**To: All Staff**  
**From: Environmental Health**  
**Date: April 29, 2026**  
**Subject: BL-26-00005**

**TO:** All Staff  
**FROM:** Public Works Plan Review Team  
**DATE:** April 23, 2026  
**SUBJECT:** BL-26-00005 Mattson

MATTSON PROPERTY

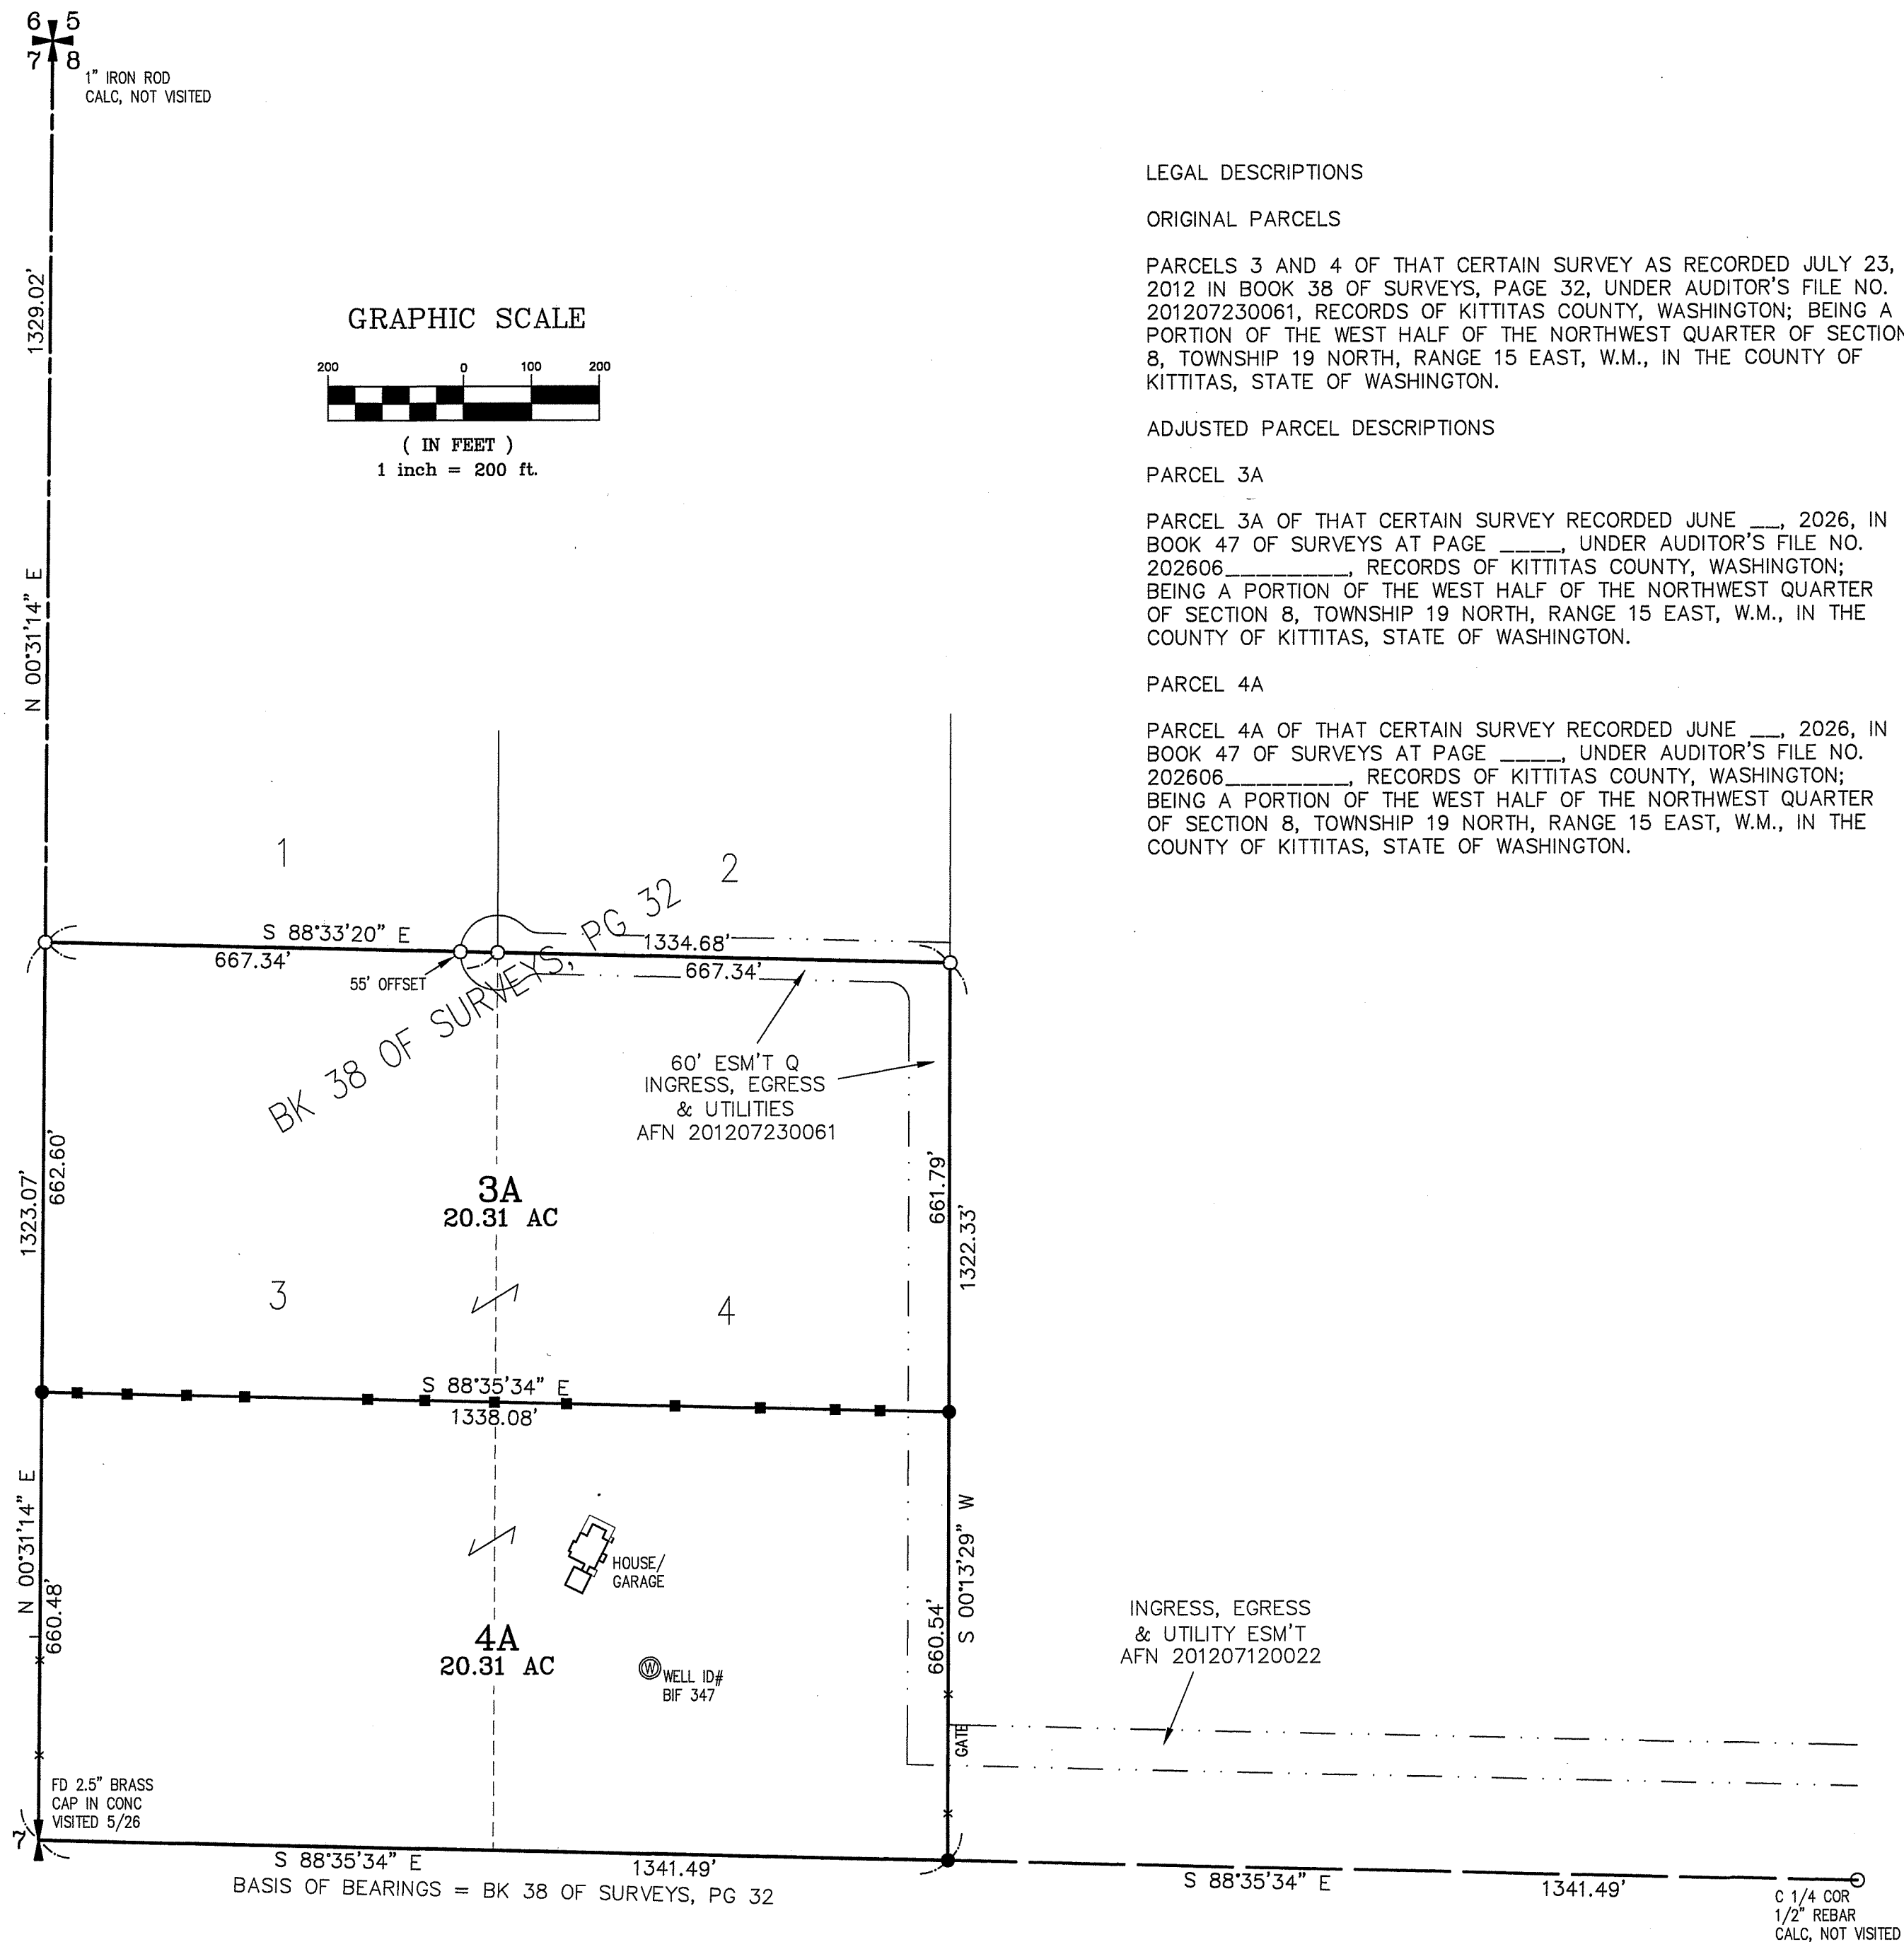
<b>Drinking Water</b>	<ul style="list-style-type: none"><li>• For any boundary lines in proximity to wells, please ensure that property lines are not relocated within 50 feet of wells.</li></ul>
<b>Wastewater</b>	<ul style="list-style-type: none"><li>• Please confirm that all septic systems are located at or beyond the minimum proposed setback distances from property lines.</li></ul>
